# Gatwick Airport Northern Runway Project

Response to the Examining Authority's Written Questions  
(ExQ2) – Landscape, Townscape and Visual Resources

Application Document Ref: 10.56.10

PINS Reference Number: TR020005

FIGURE 8.6.3

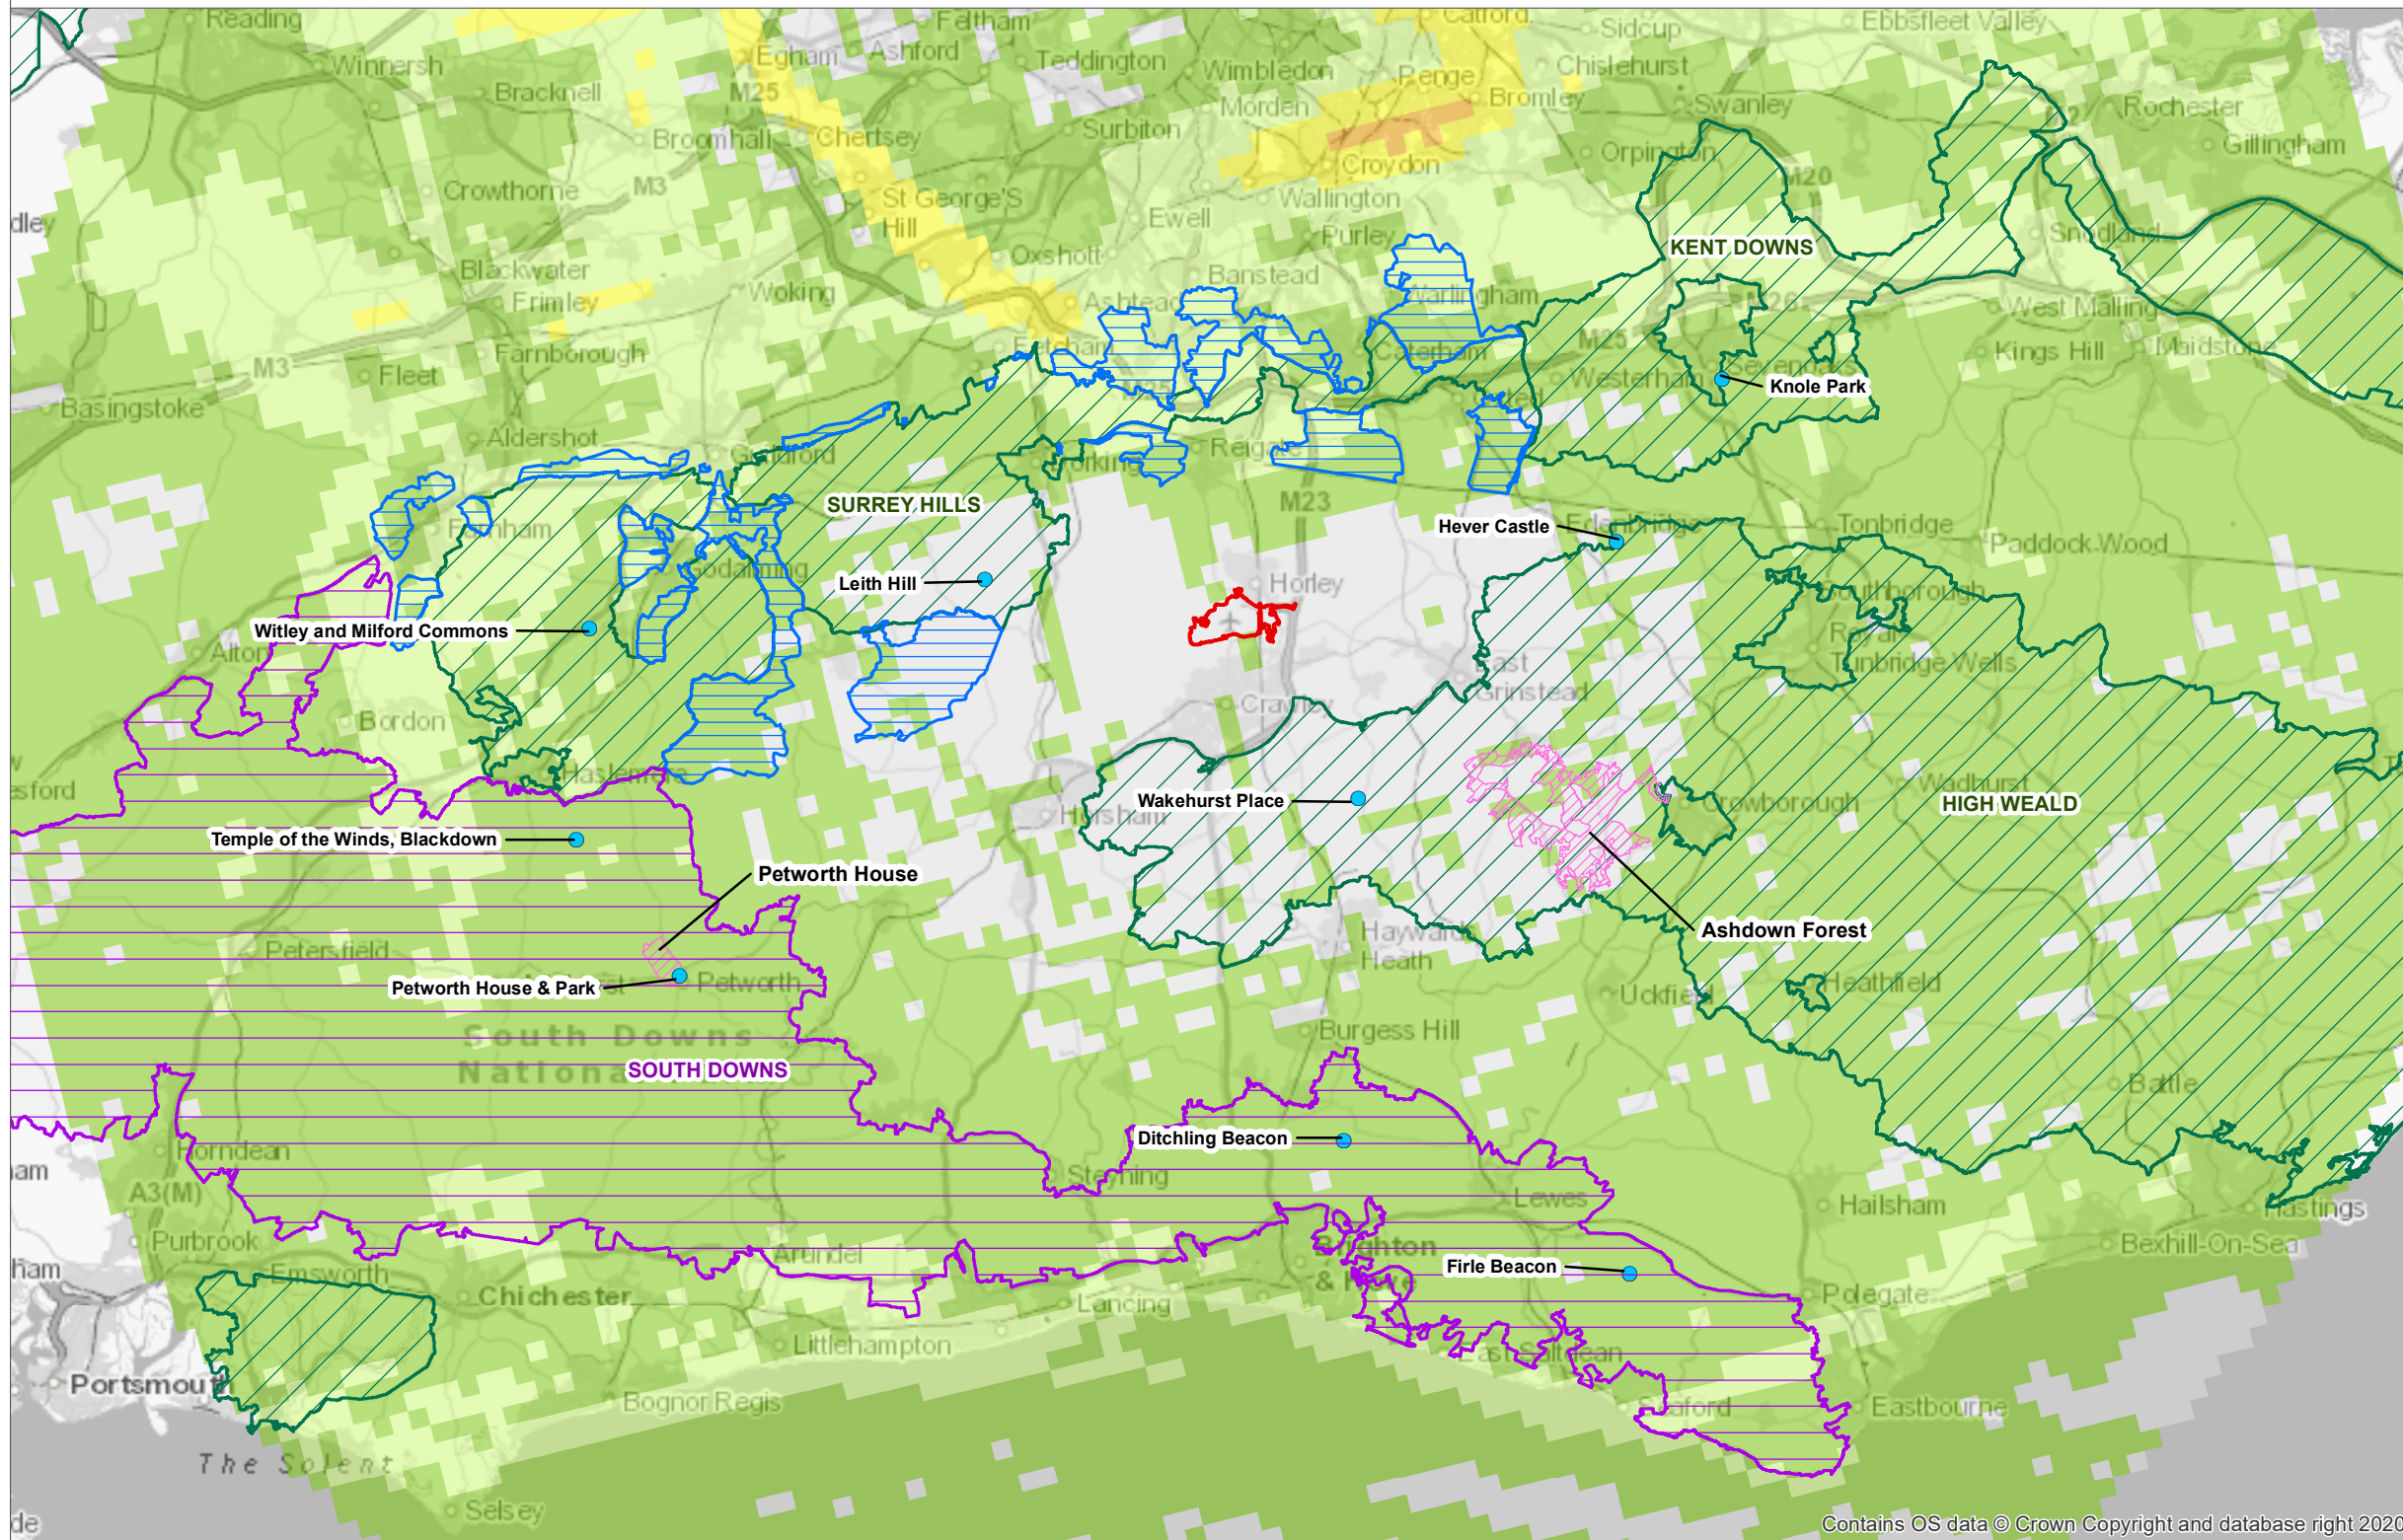
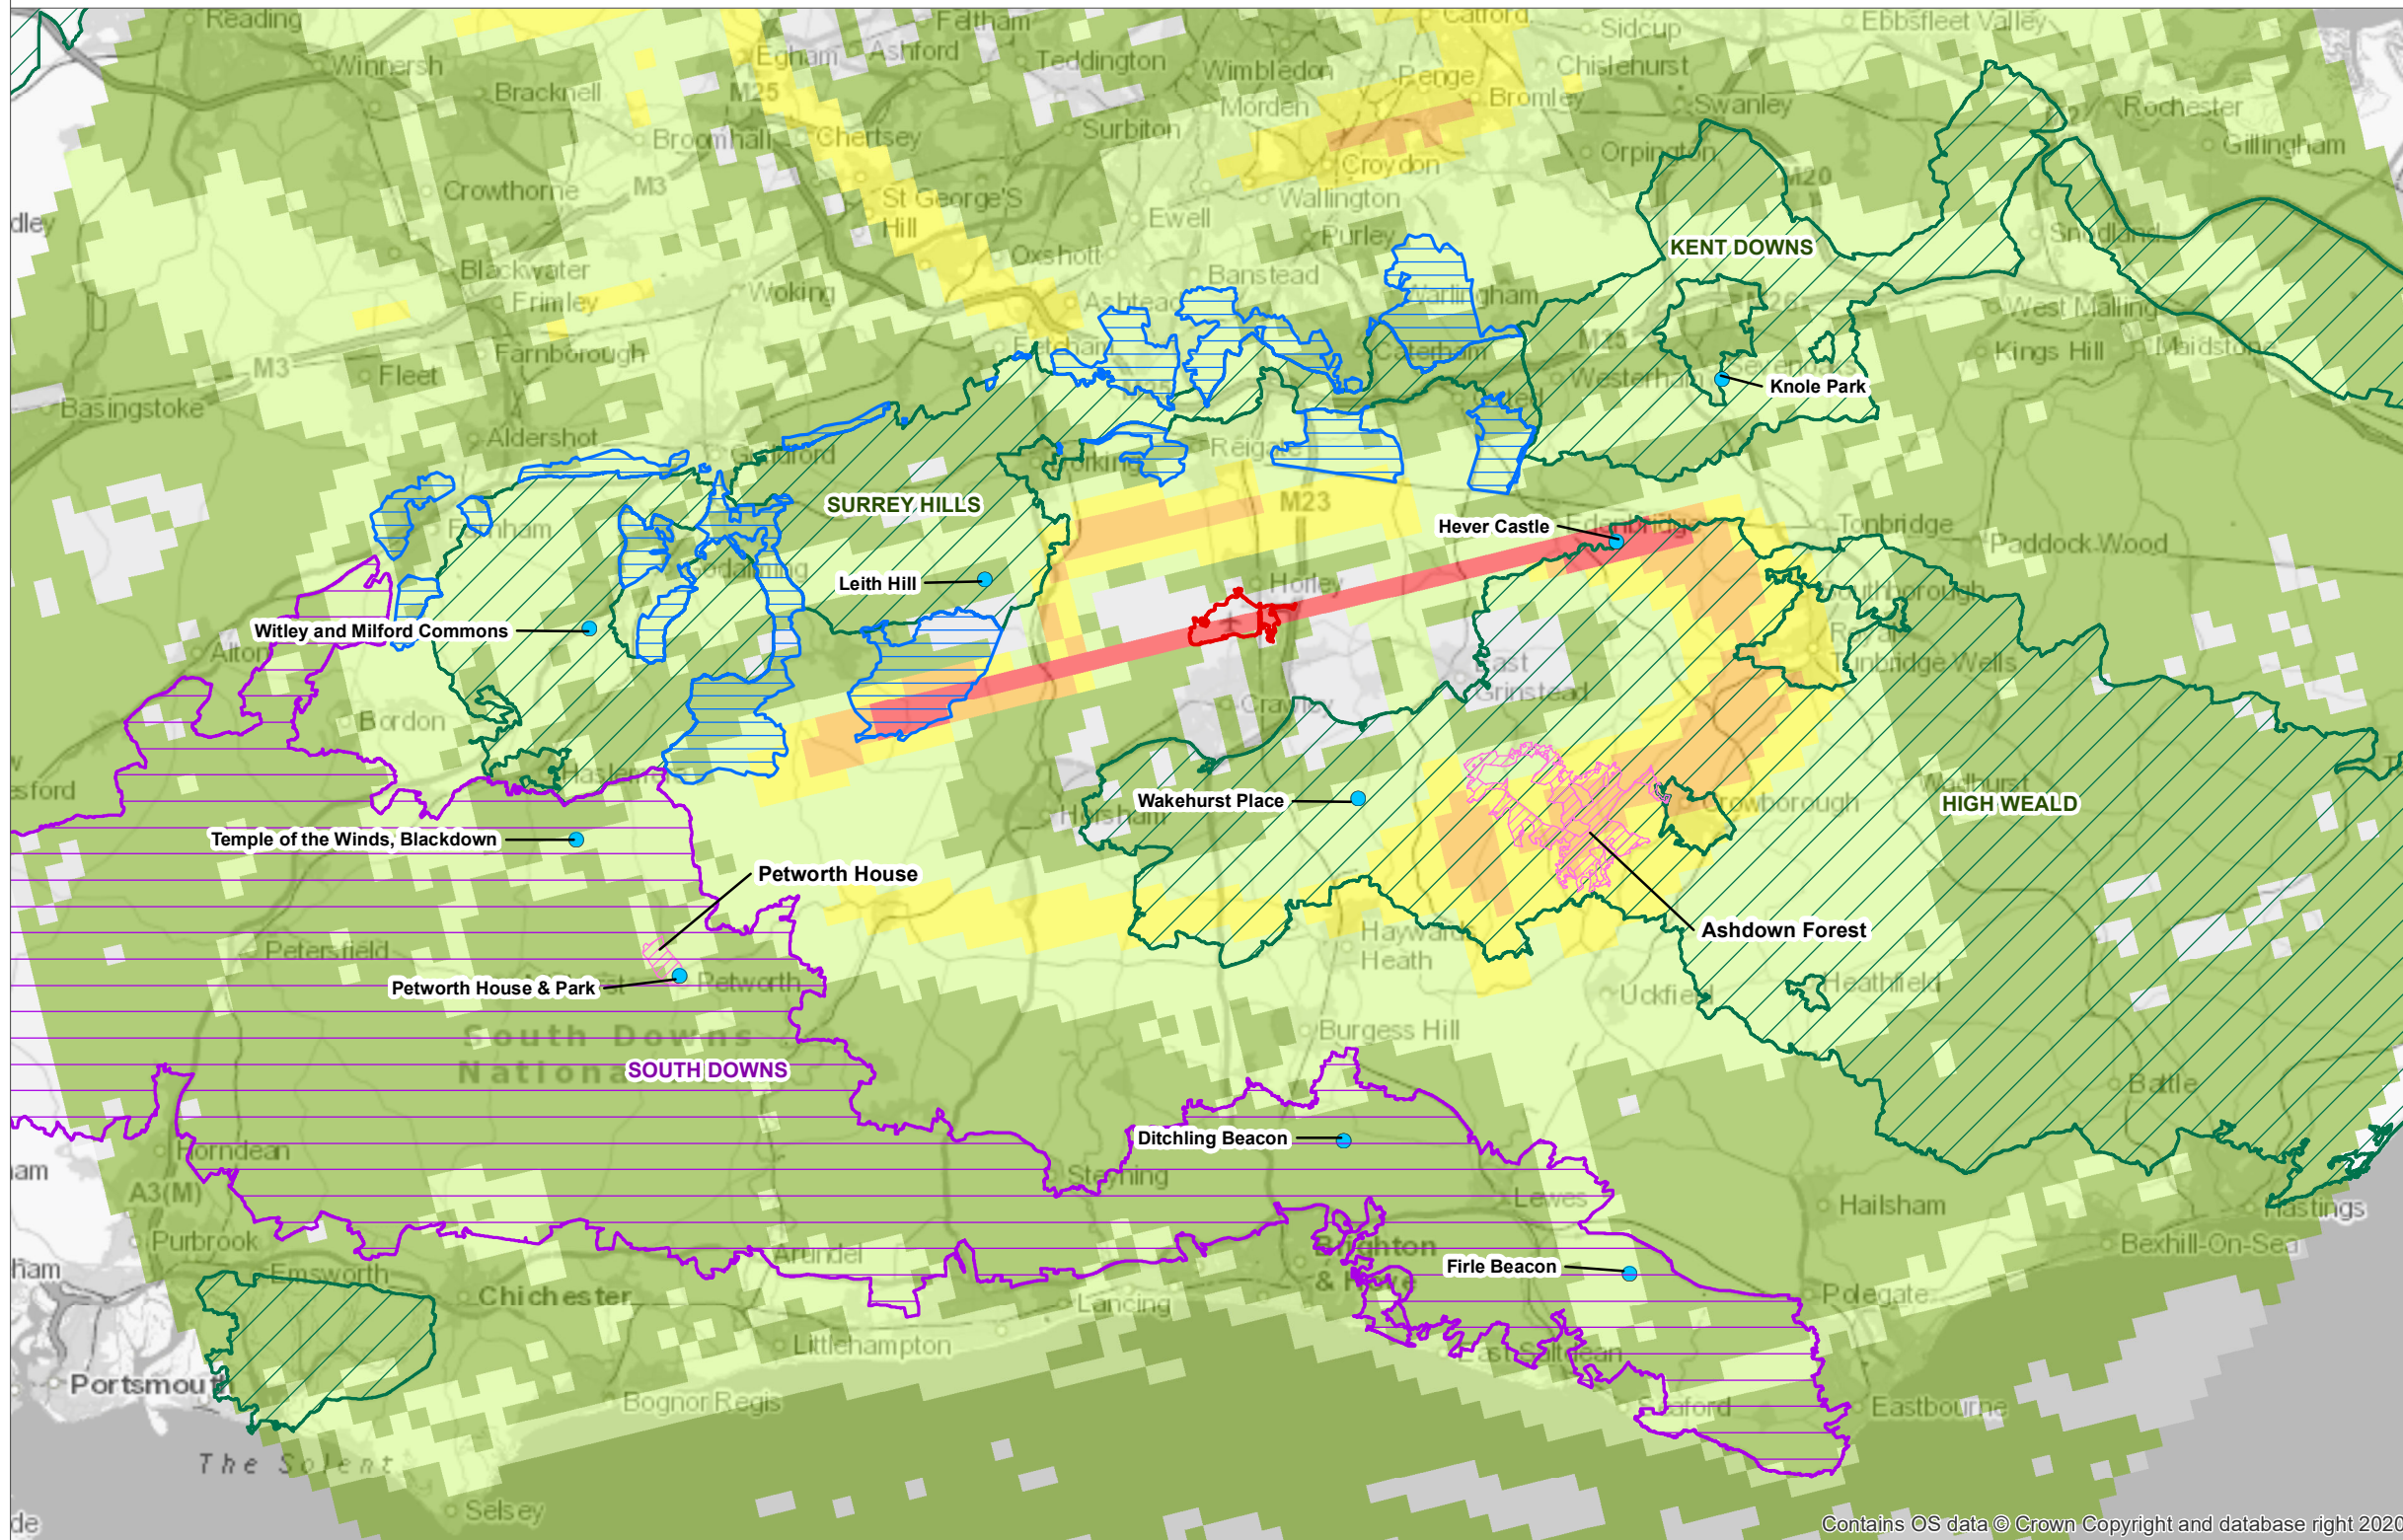
LV.2.2	Applicant	<p><b>Surrey Hills National Landscape</b></p> <p>While noting the answer to ExQ1 LV.1.8 and Appendix B to that answer, please provide further information concerning the likely extent of overflying (in terms of numbers and increase) which may occur over the proposed extended areas of the Surrey Hills National Landscape as a result of the Proposed Development.</p> <p>In addition to the survey and analysis work undertaken to inform the answer to ExQ1 LV.1.8 in <b>Applicant's Response to the ExA's Written Questions (ExQ1) - Landscape, Townscape and Visual Resources – Appendix A</b> [<a href="#">REP3-097</a>, <a href="#">REP3-099</a>] the Applicant updated the overflight heat maps ES Figures 8.6.3 to 8.6.7 in <b>ES Landscape, Townscape and Visual Resources Figures - Part 2</b> [<a href="#">REP2-007</a>] to identify the 15 Surrey Hills National Landscape Evaluation Areas for the proposed extension to the landscape designation, see Appendix A. The heat mapping for the proposed overflights, during both day and night time, is based on a forecast increase as a result of the Project by comparison to the future baseline situation of up to approximately 20% overflights by the end of 2032 and would not exceed this level of increase beyond 2033. No new flight paths are proposed as part of the Project. The increase in audible or visible overflights as a result of the Project is most likely to influence the perception of tranquillity within landscapes defined as Evaluation Areas 10, 11 and 12 to the north-east, north and west of Gatwick airport respectively. The areas of these landscapes which are currently overflown by the largest number of aircraft would experience the greatest number of additional aircraft, where relative tranquillity is slightly lower. No areas of landscape would experience an increase in overflights of more than 20%, therefore the assessment within the <b>ES Chapter 8: Landscape, Townscape and Visual Resources</b> [<a href="#">APP-033</a>] remains valid. The special qualities experienced by people including distant scenic views and relative tranquillity and dark skies would be affected to some extent however, they would still be positive qualities that would be experienced. An increase of up to approximately 20% in the number of aircraft following the same flight paths may be discernible to some residents or observers or barely perceptible to others. The magnitude of change would be negligible, leading</p>

to minor adverse effects on the perception of tranquillity during the day and at night, which is not considered to be significant.
LV.2.3	Applicant	<p><b>Visualisations</b></p> <p>The visualisations provided with the proposal show wireframe visualisations superimposed onto existing baseline viewpoint photography. Consider whether more detailed visualisations/ photomontages would be useful for certain sensitive viewpoints where visual effects would be most pronounced (including visualisations at certain times, for instance during construction, year zero, year fifteen) and provide them if appropriate or provide justification if not.</p> <p>The Applicant provided a <b>Note on Project Wide Habitat Loss and Replacement</b> <a href="#">[REP6-071]</a> at Deadline 6 to form a single point of reference with respect to a worst case habitat change that would result from the Project. The document includes illustrative material for eight key views within the surface access improvements corridor to illustrate vegetation loss and replacement and the creation of landscape proposals. The figures are based on panoramic site photography to show the existing situation with Photoshop visualisations to demonstrate landscape proposals at Year 1 and Year 10. The visualisations were prepared to the specifications set out by RBBC following a meeting on 14<sup>th</sup> May 2024. The locations of the visualisations are focussed within the surface access improvement corridor where some significant effects on landscape/townscape character and visual amenity have been identified within <b>ES Chapter 8: Landscape, Townscape and Visual Resources</b> <a href="#">[APP-033]</a>.</p> <p>The following documents provided by the Applicant are considered appropriate and sufficient to enable an understanding to be gained of the scale, mass and nature of development proposals and the character and concept of landscape and ecological proposals within the Project and how they interact with built form and infrastructure;</p>
